2024/0419

41 Broomhead Road, Wombwell, Barnsley, S73 0SA

Erection of single storey rear extension and rendering of side elevation of two storey semi-detached dwelling

41 Broomhead Road, Wombwell, S73 0SA  
PROPOSED FLOOR PLANS  
& ELEVATIONS

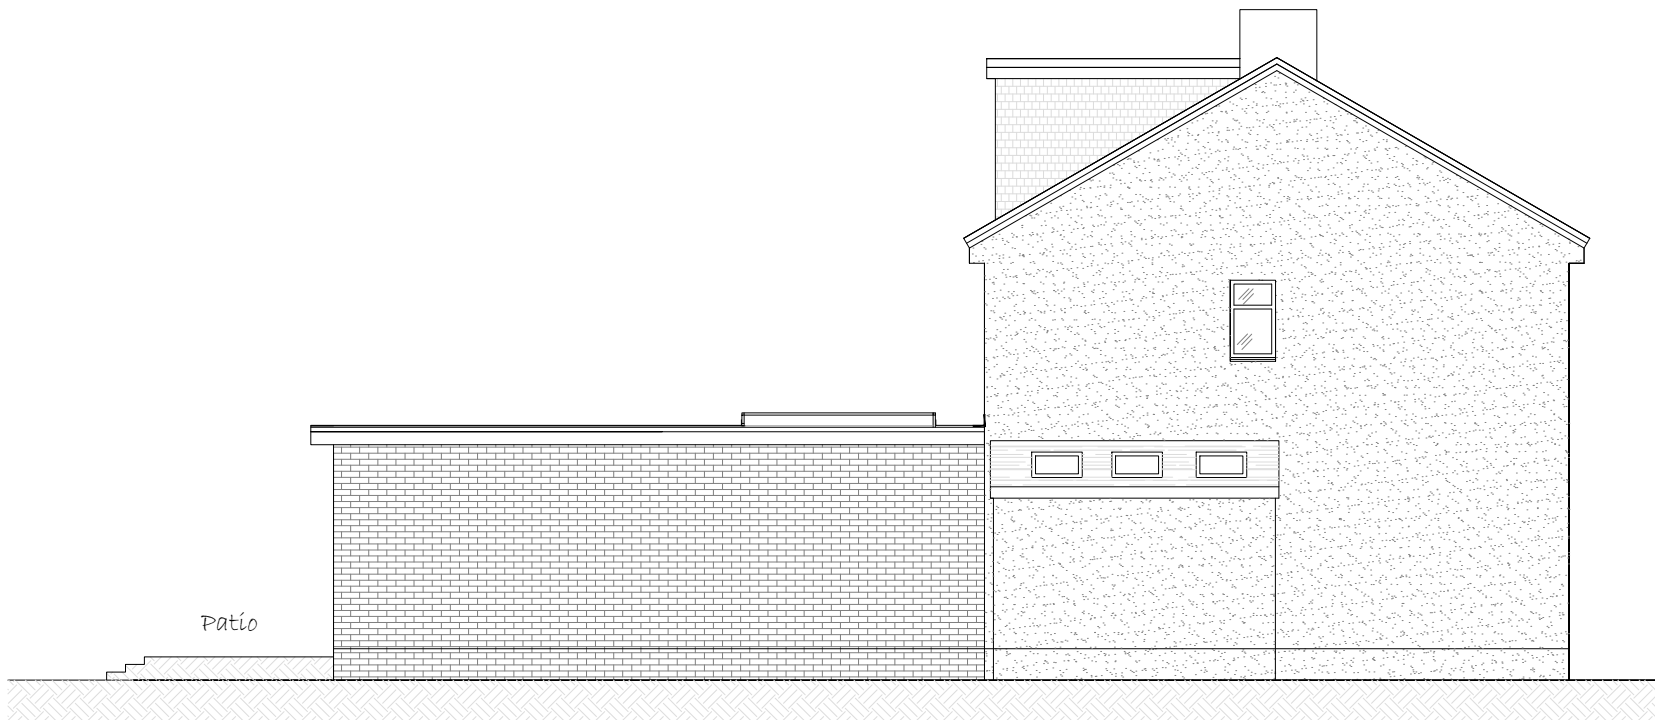
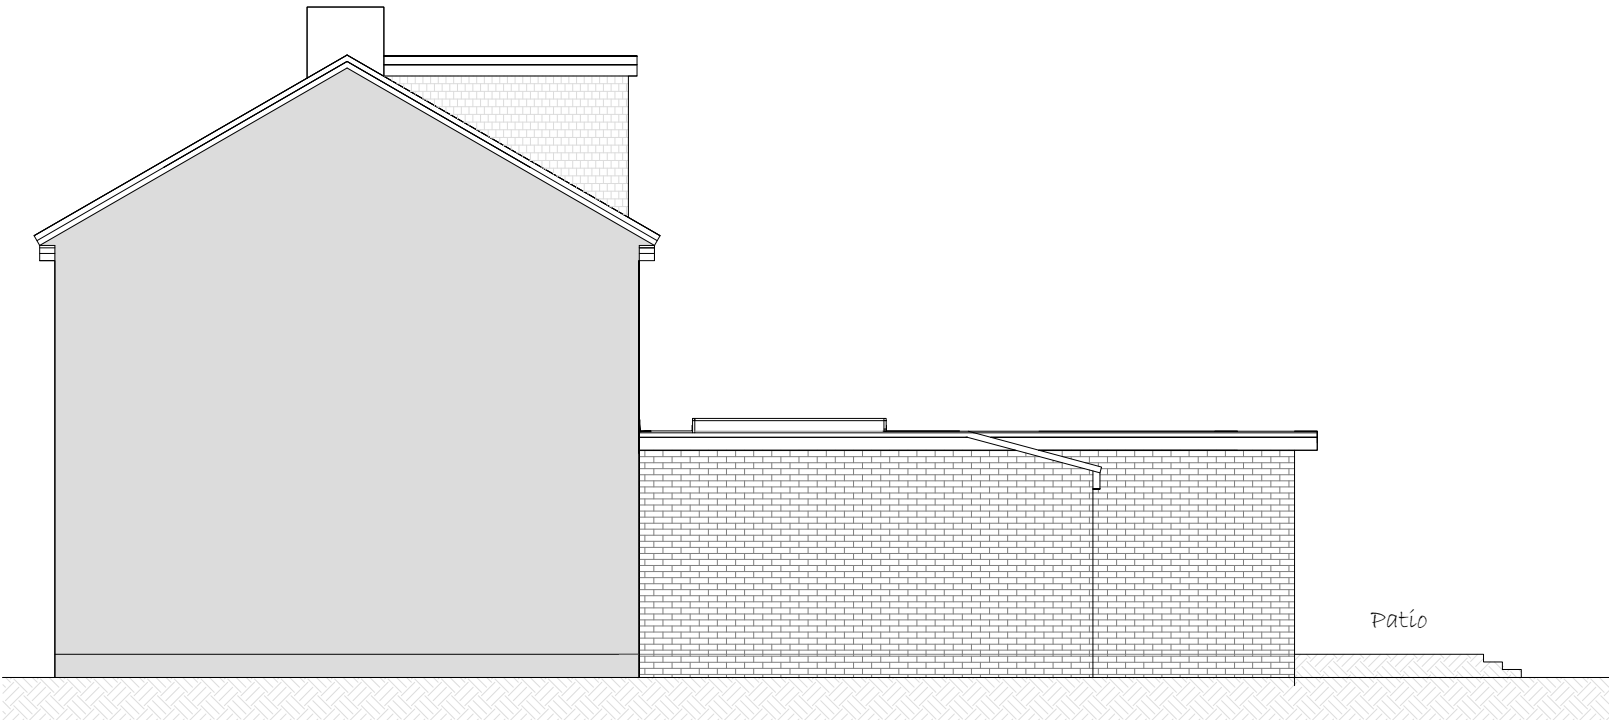
The SPD states that single storey rear extensions *“on semi-detached dwellings should not project more than 4m and again, the eaves height should not exceed 2.5m where the extension would project beyond 3m”*. The proposed extension has a total projection of 8.65 meters which is greater than the recommended 4 meters. However, the Government allows for extensions larger than the above to be permitted development by using a prior notification for larger homes application, subject to no objections being received.

The extension predominantly utilises a flat roof. Although a slight lean to is proposed, a long flat roofed section is still maintained. Flat roofs are not a supported roof type due to flat roofs being an inferior form of construction. This combined with the proposed projection and materials would account to poor design in the opinion of the LPA. However, in the appeal decision the inspector commented on the use of the flat roof being acceptable, stating:

Broomhead Road consists predominantly of brick-built dwellings. Given that the surrounding street scene is made up of entirely brick-built dwellings with no render in the street scene, the use of render would be harmful to the original character of the dwelling and the street scene as a whole. It is noted the use of render has been reduced from rendering the whole dwelling on the previous application to only rendering the side (northwest) elevation in white.

For the reasons given above and taking all other matters into consideration including the appeal decision and fallback position, the proposal is to be approved, and permission should be granted subject to necessary conditions. In this specific circumstance the application is therefore recommended for approval. It is noted the enforcement issues with this property in the past and if the extension is not built as approved then legal action will be taken against the applicant. Finally no other part of the dwelling is to be rendered other than the side (northwest) elevation.
